DRB CASE ACTION LOG

DRB Application No.: 03-01039 (P&F)	Project # 1002502
Project Name: MRGCD MAP 38	EPC Application No.:
Agent: Michael Renfro	Phone No.: 345-8971

APPLICATION NO. 03DRB - 01039	PROJECT NO. 1002502
PROJECT NAME (MRGCD MAP 38)	Herrera Gardens
EPC APPLICATION NO.	
APPLICANT / AGENT Mike Renfro	PHONE NO. 345-8971
ZONE ATLAS PAGE J-15

MICHAEL RENFRO request(s) the above action(s) for all or a portion of Tract(s) 338-A-1-B-1, **MRGCD MAP 38**, zoned R1, located on HERRERA NW, between ATRISCO NW and 47th ST NW containing approximately 2 acre(s). [REF: 03DRB-00293-SK] (Preliminary Plat was approved 7/9/03, Final Plat was indefinitely deferred) (J-12)

PLAT OF TRACTS A, B, C & D HERRERA GARDENS

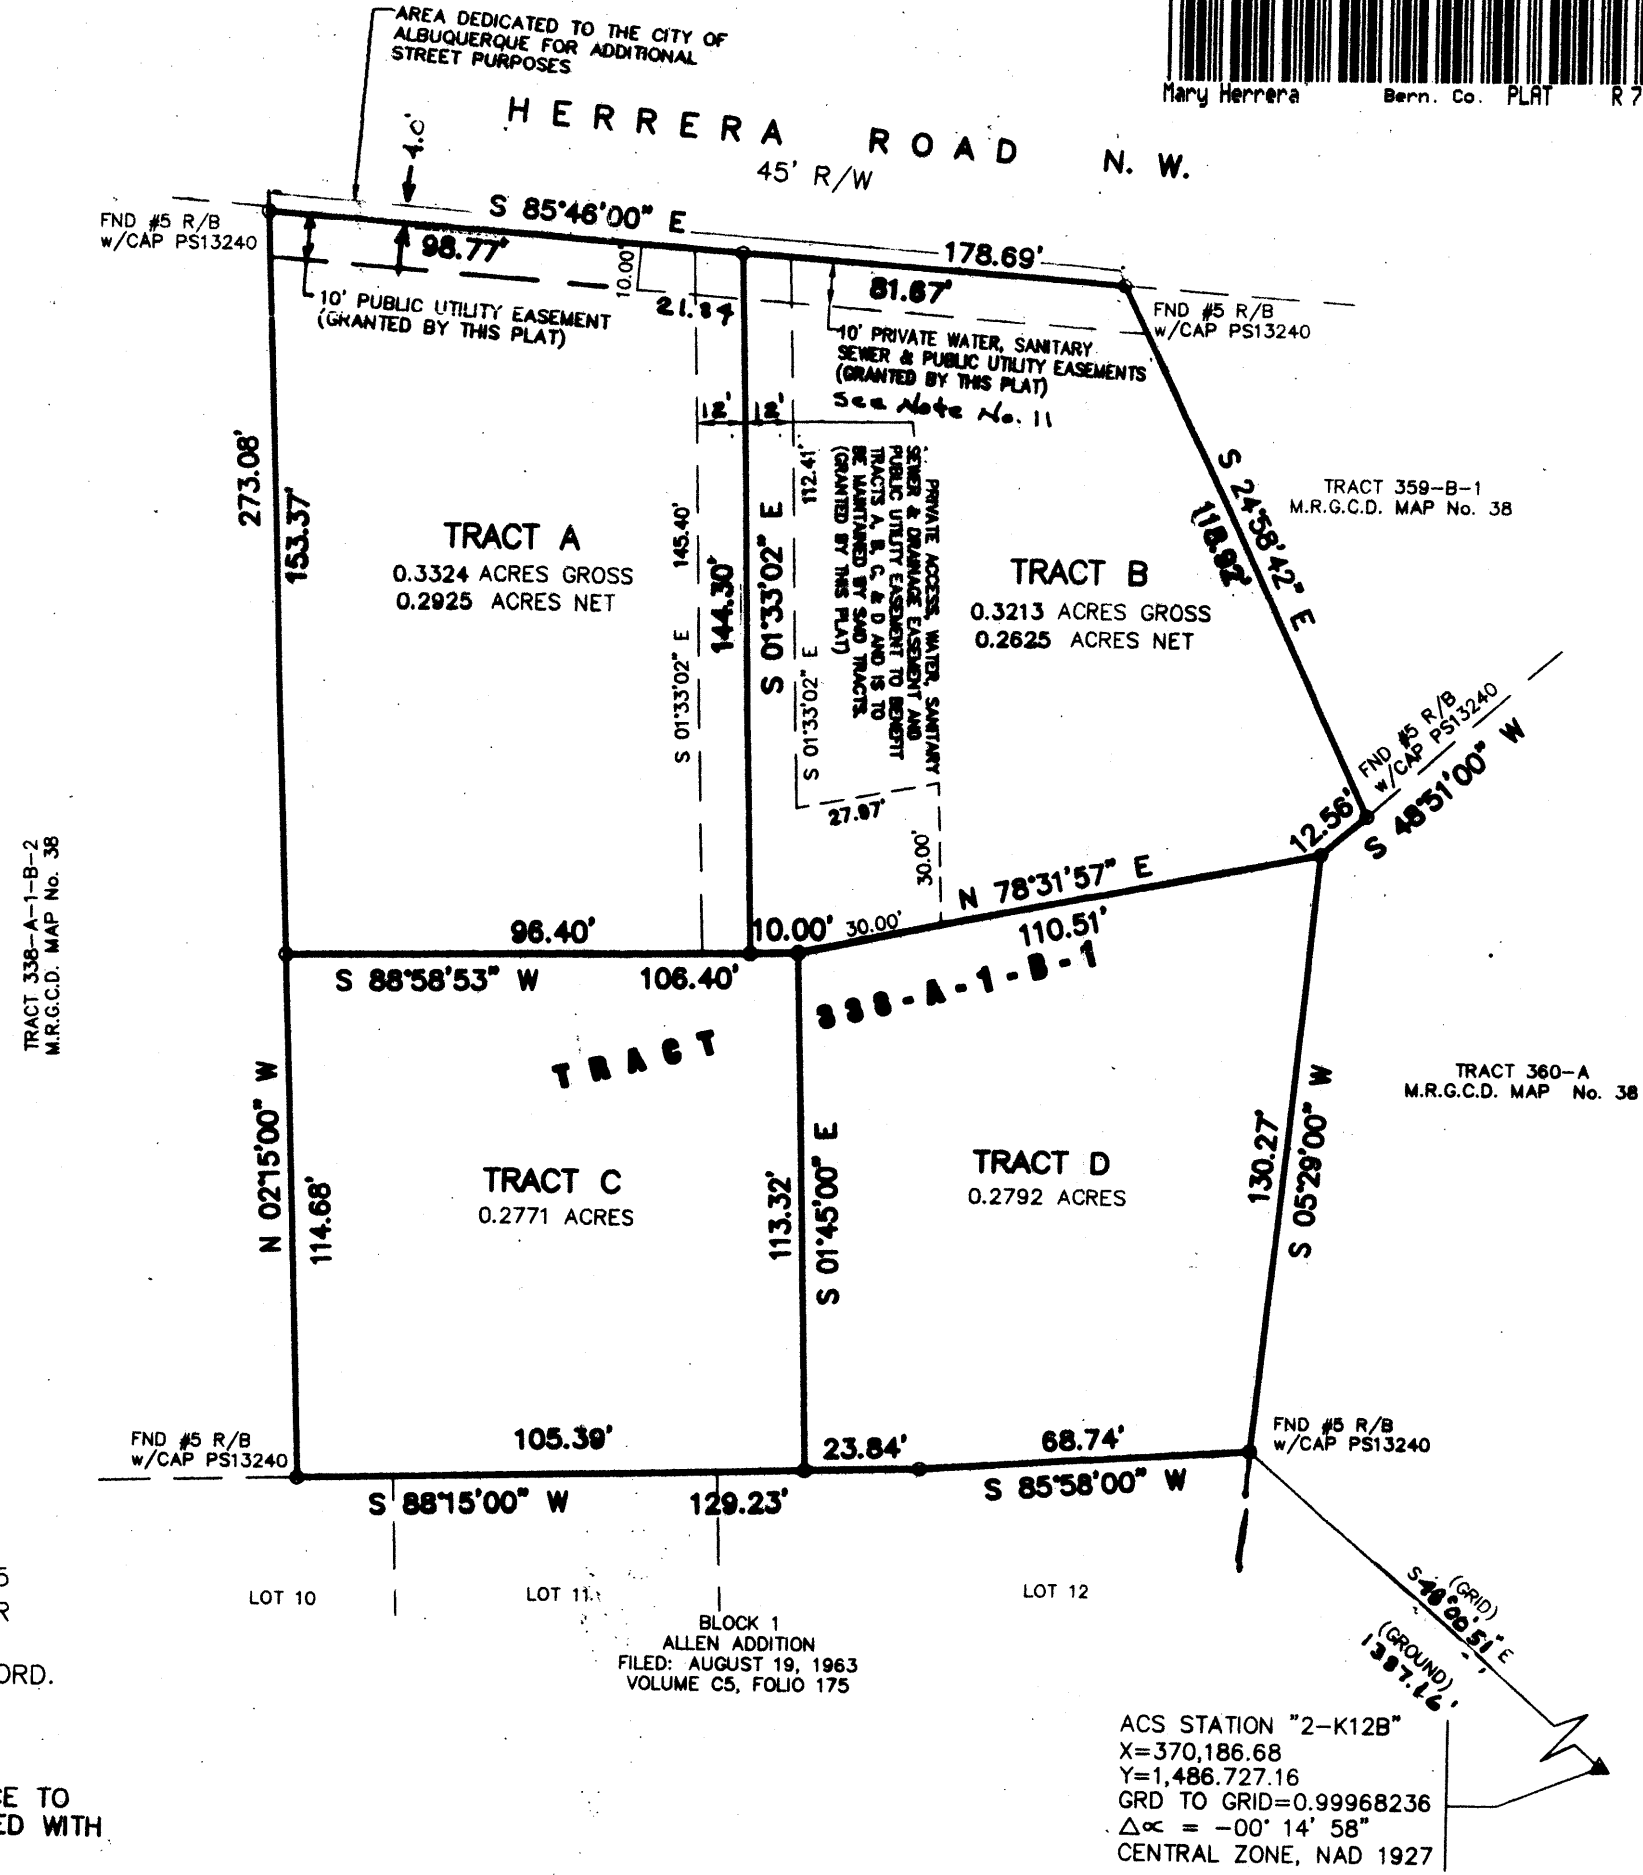
Need merit/beneficiary language for 10' private easement North side Tr. B.

Add to fee consent the dedication language for ROW in fee simple

No.	Comment
<input type="checkbox"/>	Dedication of right-of-way is needed, 9ft from the face of curb on Herrera, 10ft on Atrisco with 20ft radius at intersection.
<input type="checkbox"/>	The access easement needs to be 24ft wide, if sidewalk variance is granted with gravel.

Need private access easement to include drainage.

At the July 23, 2003, Development Review Board meeting, the final plat was approved with final sign off delegated to Utilities Development for maintenance and beneficiary language for a 10-foot private easement at the north side of Tract B and to add to free consent statement the dedication language for right-of-way in fee simple and Planning for the DXF file.
